**Office of
Environment
& Heritage**

RE: HUME COAL & BERRIMA RAIL PROJECTS EIS EXHIBITION (SSD 7172 & SSD 7171)

ATTACHMENT A – OEH DETAILED COMMENTS – HUME COAL & BERRIMA RAIL PROJECTS EIS – SSD 7172 & 7171

Berrima Rail Project
 Appendix C1
 5 Year ARI flood extent - Operation (Preferred option)

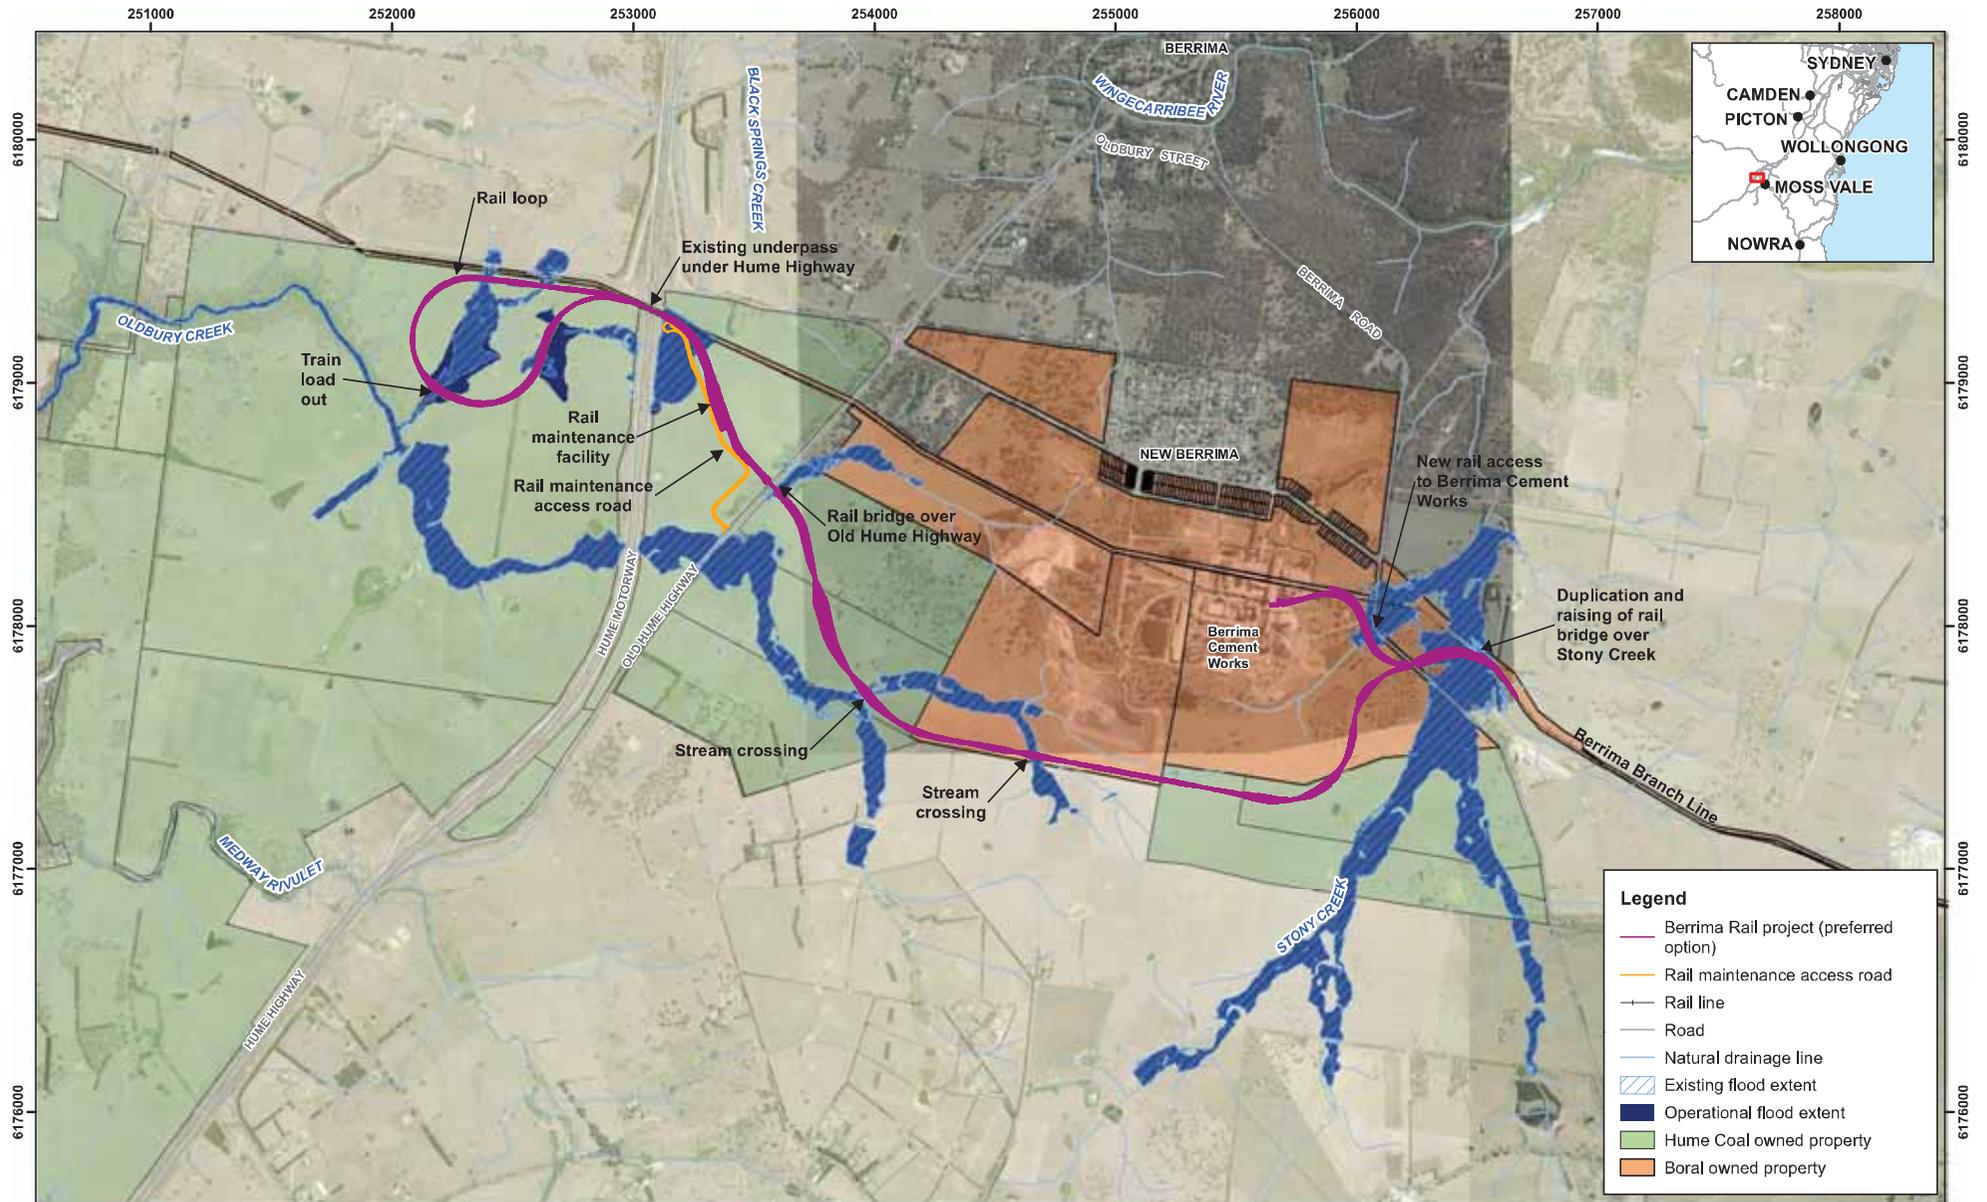
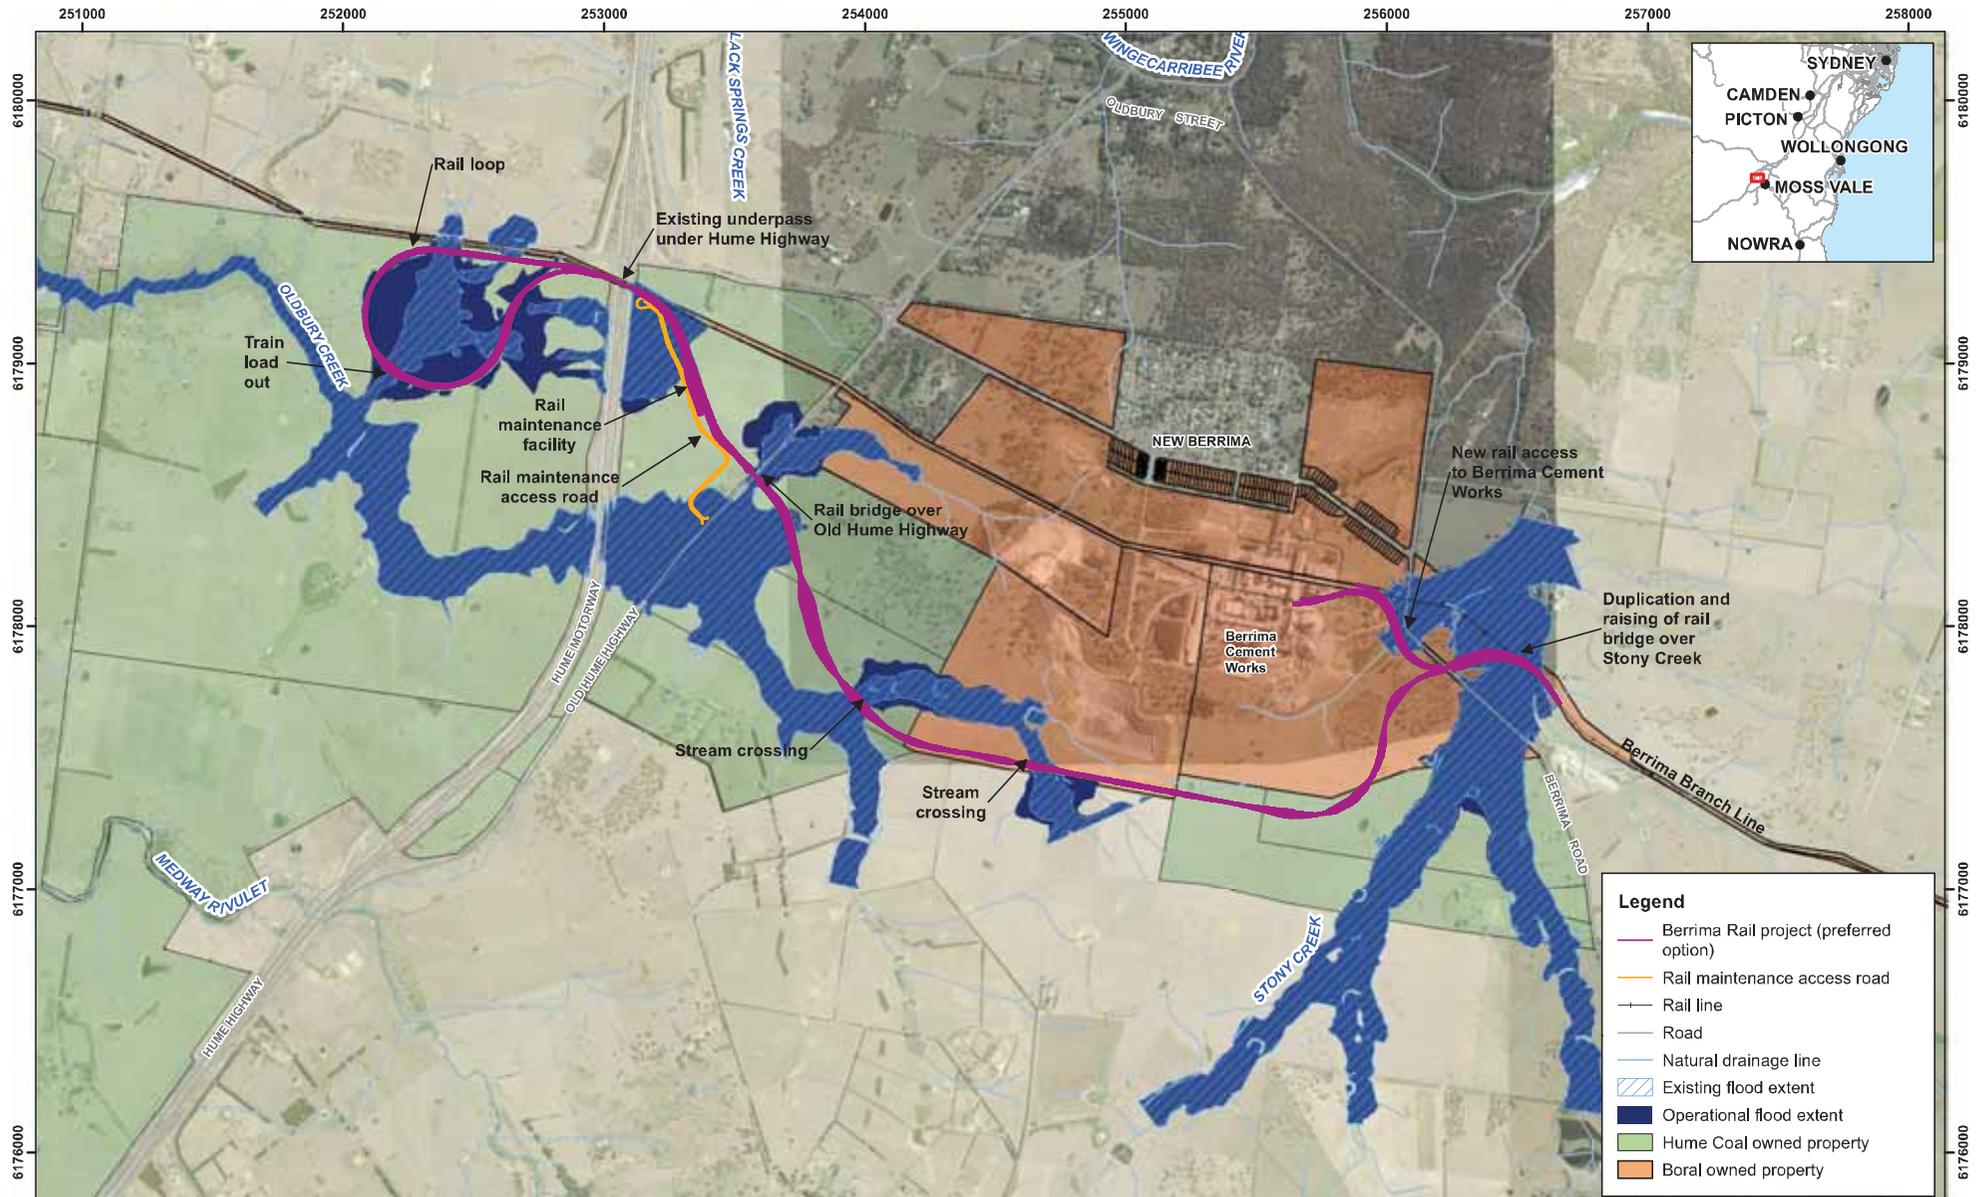
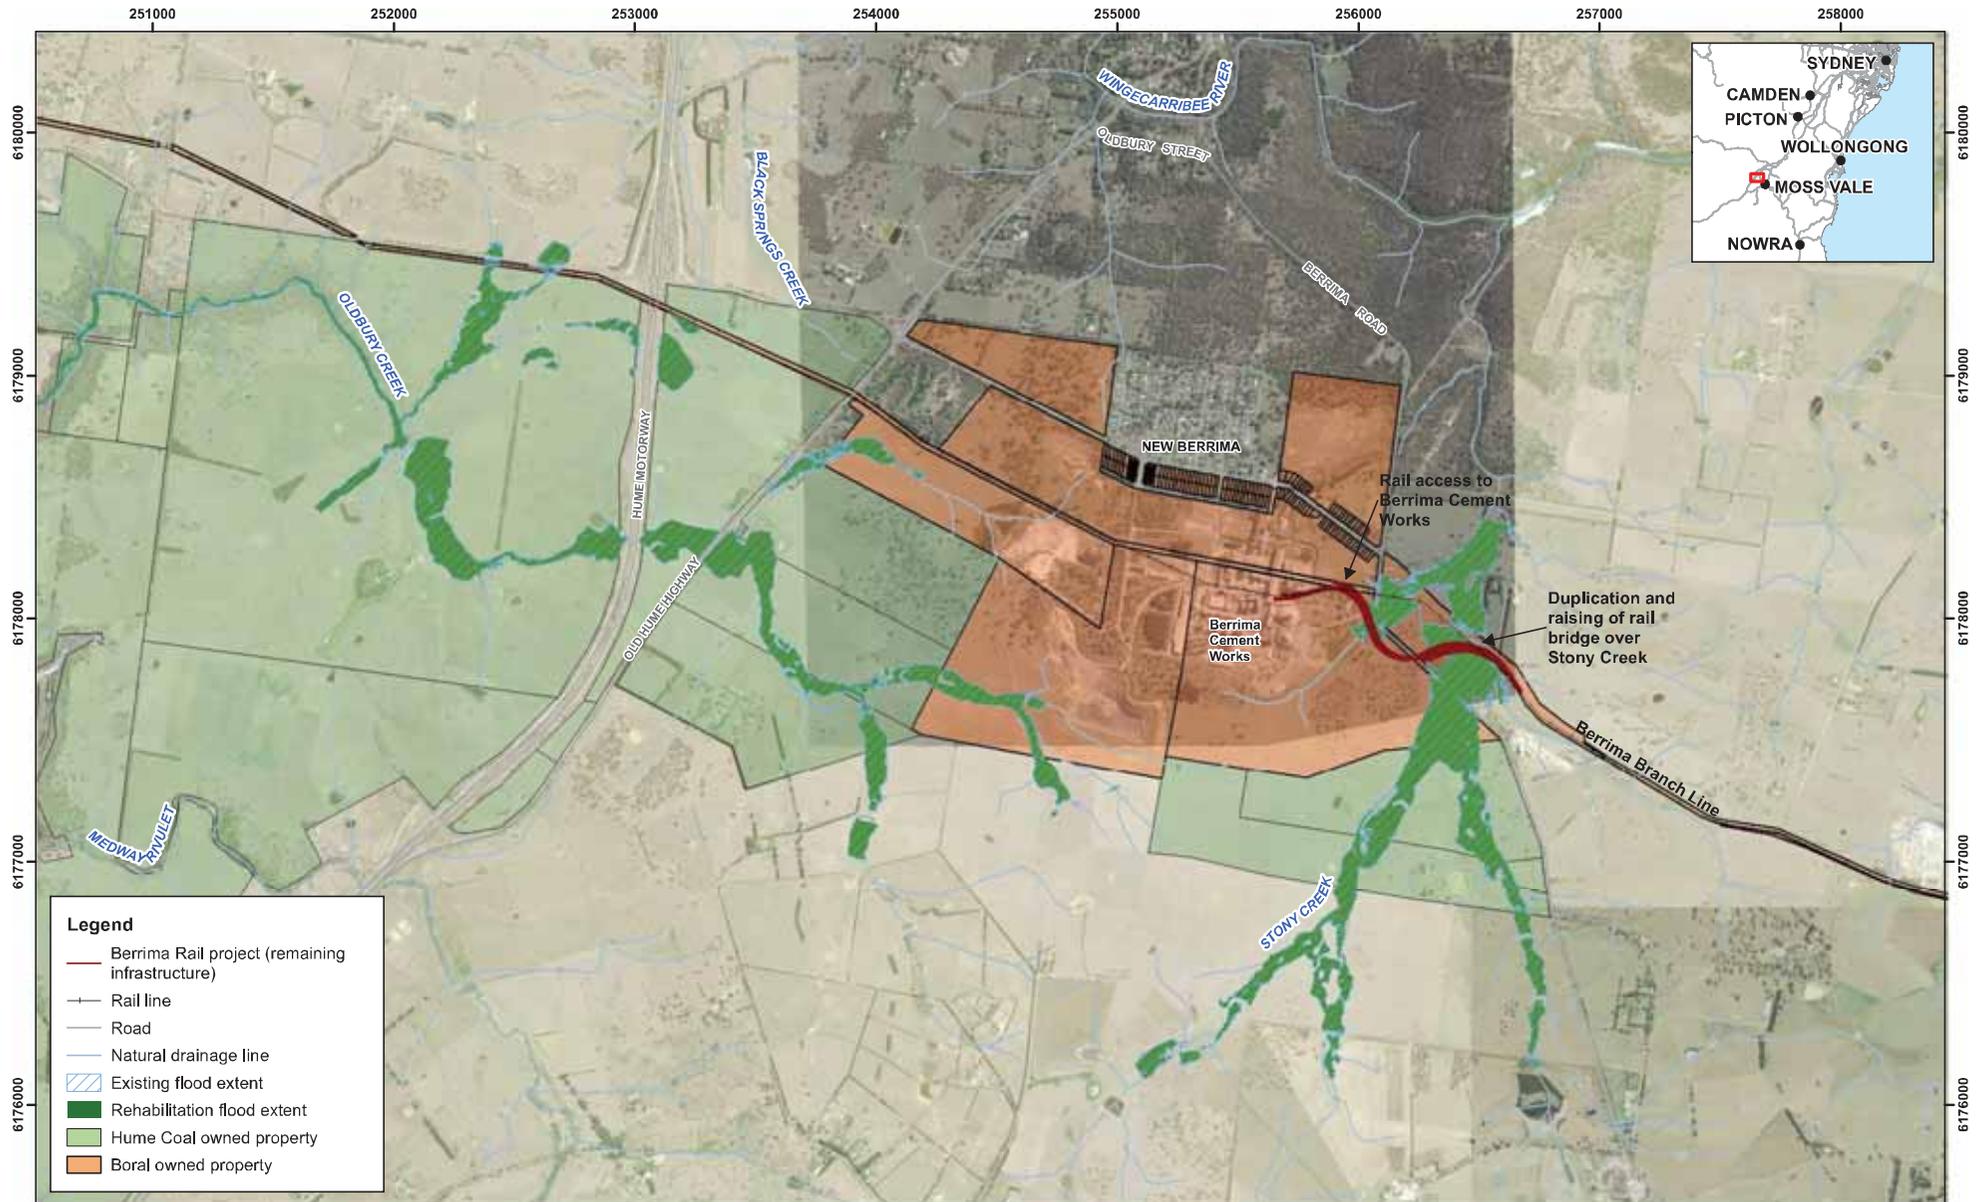
OEH consulted the Wingecarribee River Flood Study (2014) and formed the view that the Hume Coal proposal did not appear to occupy flood prone land. However the Berrima Rail Project does.

The implications of this are not assessed sufficiently. The degree or frequency of flooding that the rail infrastructure will experience is unclear. It is also not known what inconvenience or serviceability implications will arise for the rail project from the flooding regime. The implications of the rail infrastructure on flood behaviour are also not apparent.

- 1) The following features relevant to flooding as described in the Floodplain Development Manual 2005 (NSW Government 2005) are mapped: (a) extent of probable maximum flood for the unnamed creek at Berrima Junction and the Wingecarribee River, (b) the area below the flood planning level for all watercourses, and (c) the hydraulic categorisation (floodways and flood storage areas) for all watercourses.

- 2) For all watercourses, a description of the 1 in 10 year design flood level is provided.
- 3) The effect of the Rail Project (including any fill) on the flood behaviour under the 1 in 200 and 1 in 500 year flood events for all watercourses as proxies for assessing sensitivity to an increase in rainfall intensity of flood producing rainfall events due to climate change is assessed.

- 4) The impact on existing flood behaviour for a full range of flood events including up to the probable maximum flood and impacts of the development on flood behaviour resulting in detrimental changes in potential flood affection of other developments or land be modelling for the unnamed creek at Berrima Junction and the Wingecarribee River.

- 5) An assessment of the impacts of the Rail Project on flood behaviour be provided for all watercourses. We recommend that this include: (a) whether there will be detrimental increases in the potential flood affectation of other properties, assets and infrastructure (b) compatibility with the flood hazard of the land, (c) compatibility with the hydraulic functions of flow conveyance in floodways and storage in flood storage areas of the land, (d) whether there will be adverse effect to beneficial inundation of the floodplain environment, on, adjacent to or downstream of the site and (e) whether there will be direct or indirect increase in erosion, siltation, destruction of riparian vegetation or a reduction in the stability of river banks or watercourses.
